**Planning Department
Transportation Development Services**

October 19, 2015

Re: Taco Bell Renovations
4815 4th St., NW
Traffic Circulation Layout
Engineer's/Architect's Stamp dated 10-12-15 (F14-D071)

ALL WHEELCHAIR RAMPS LOCATED WITHIN THE PUBLIC RIGHT OF WAY MUST HAVE TRUNCATED DOMES.

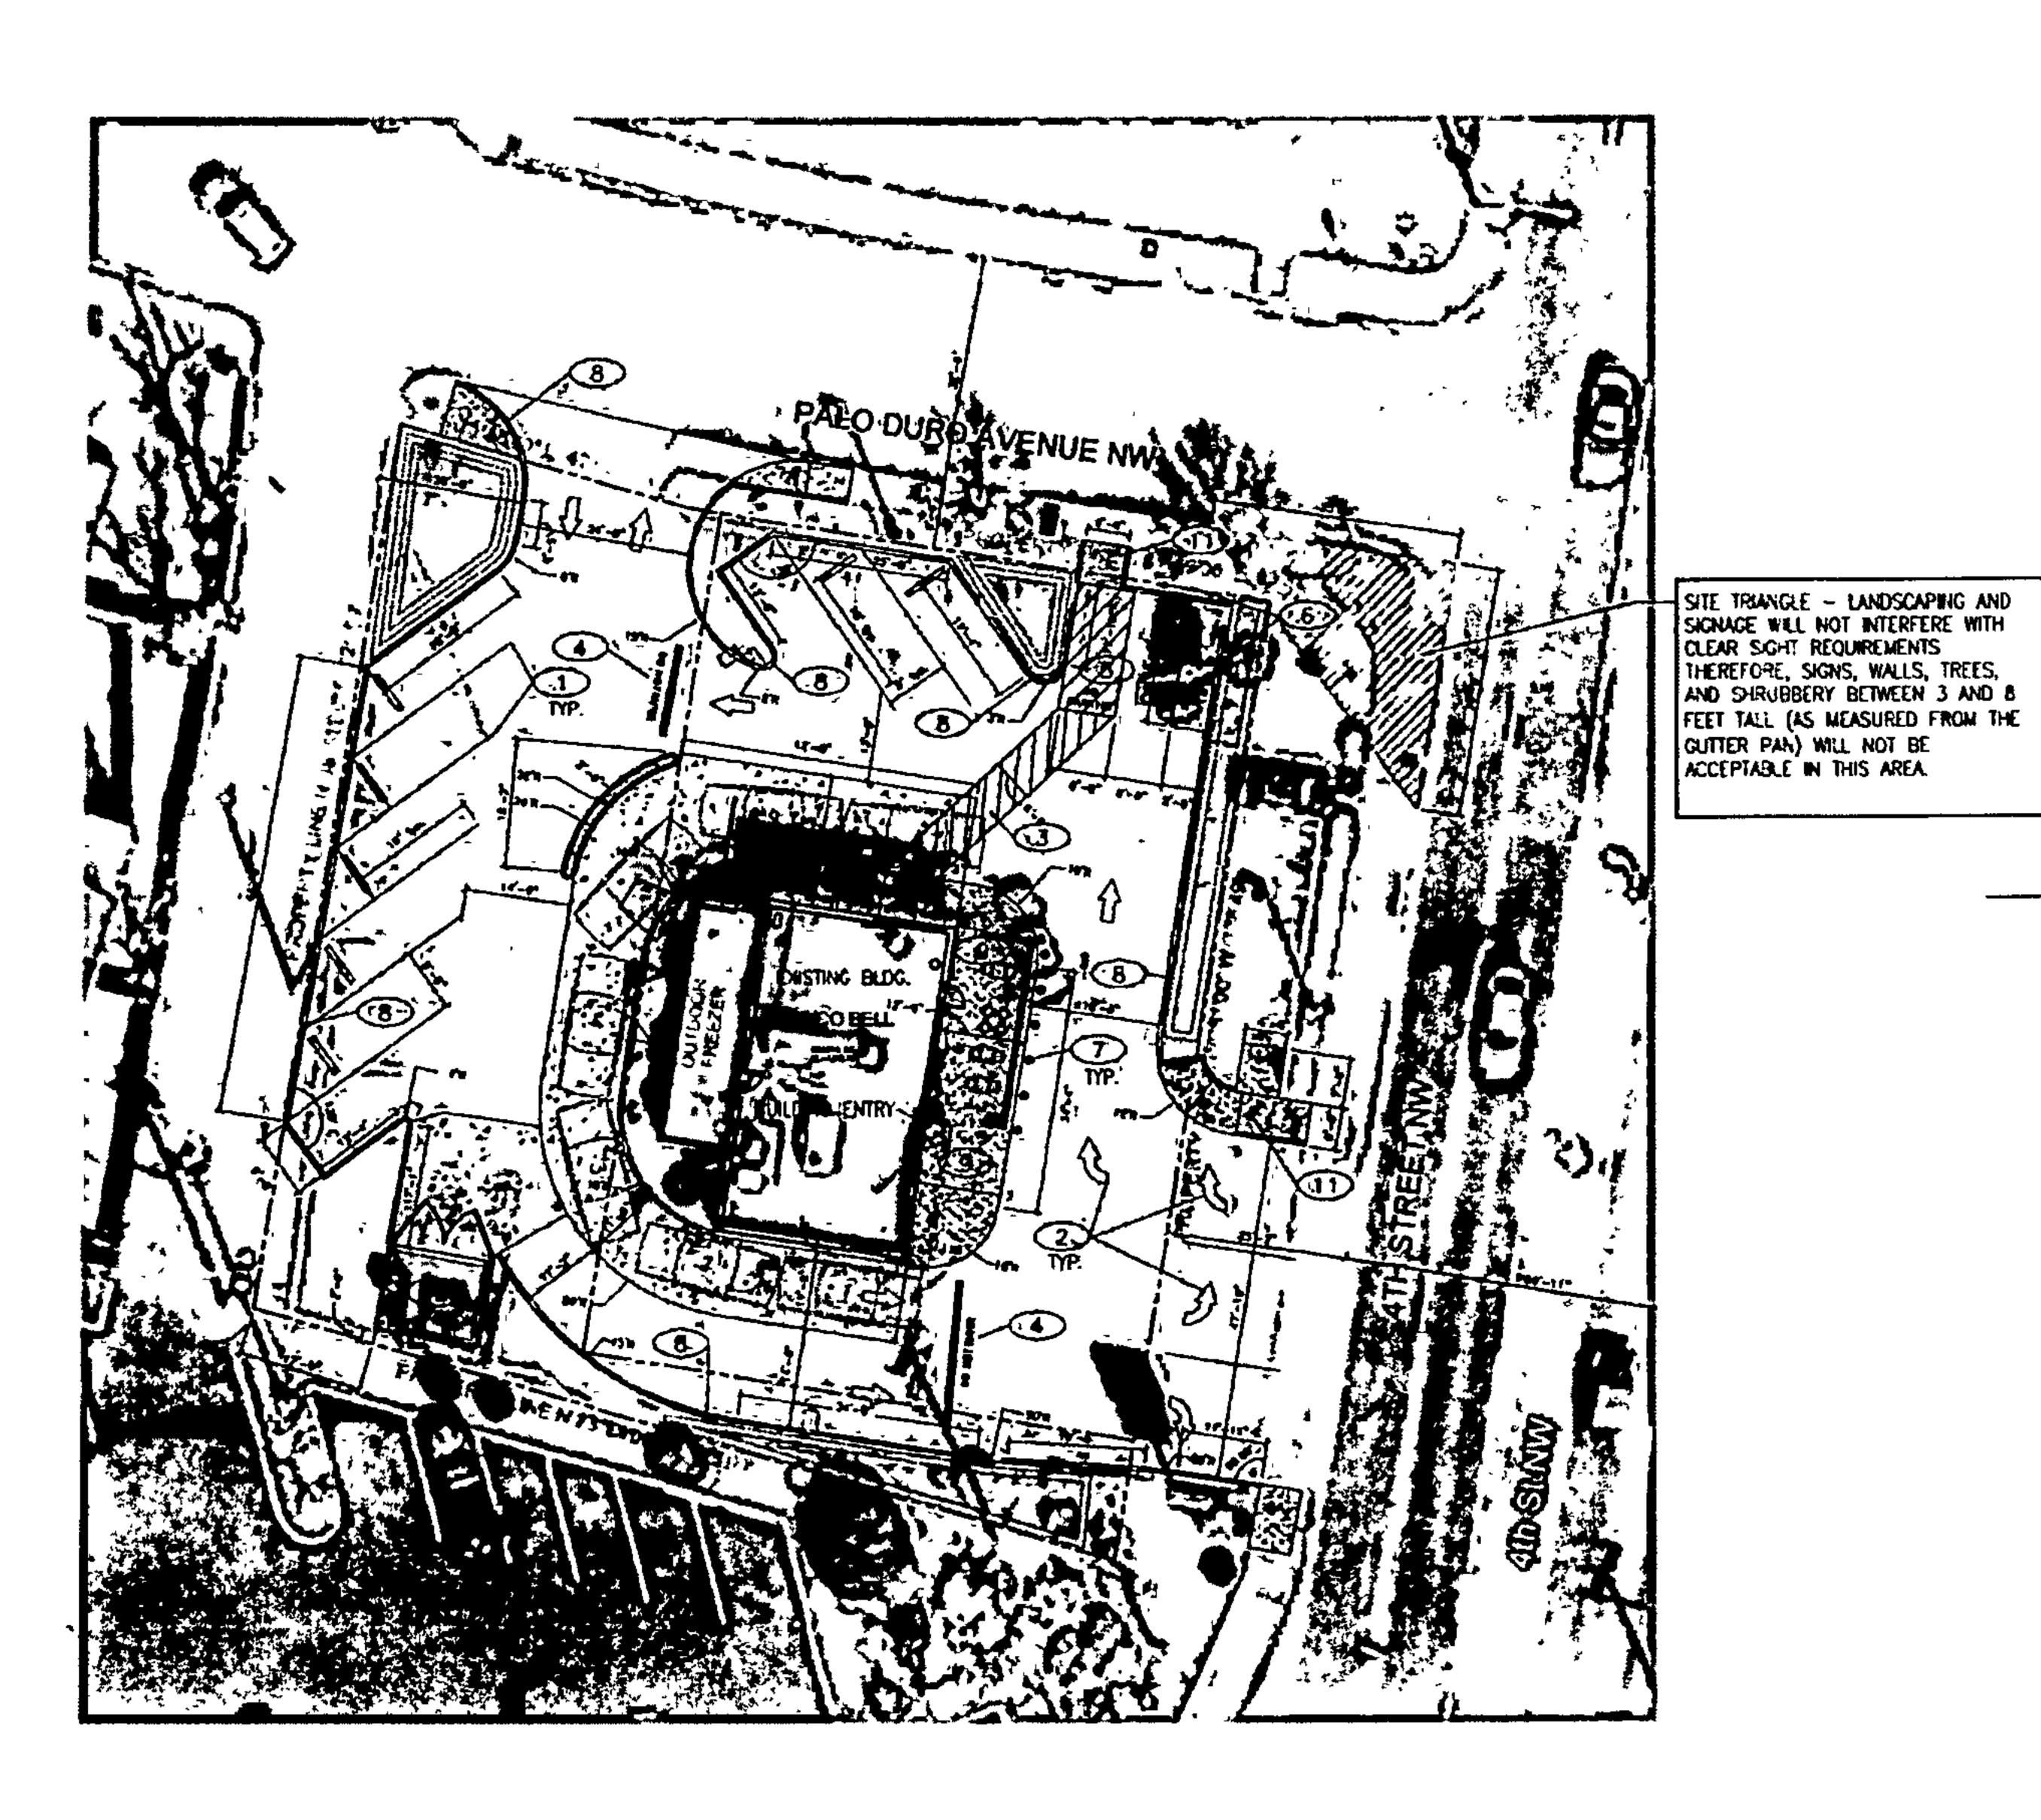
1. Please detail sidewalk and drive pad ramps on Palo Duro Ave. and 4th St. per COA City Standard specifications. ADA truncated domes need to be called out at all ramps where pedestrians cross onto traffic lanes.
2. Please provide a sight distance exhibit (see the *Development Process Manual, Chapter 23, Section 3, Part D.5 Intersection Sight Distance*). Please provide this detail for drive pad entrances/exits on Palo Duro Ave. and 4th St..

3. Please add the following note to the clear sight triangle: "Landscaping and signage will not interfere with clear sight requirements. Therefore, signs, walls, trees, and shrubbery between 3 and 8 feet tall (as measured from the gutter pan) will not be acceptable in this area." This detail is for drive pad entrances/exits on Palo Duro Ave. and 4th St..
4. Please include two copies of the traffic circulation layout at the next submittal.
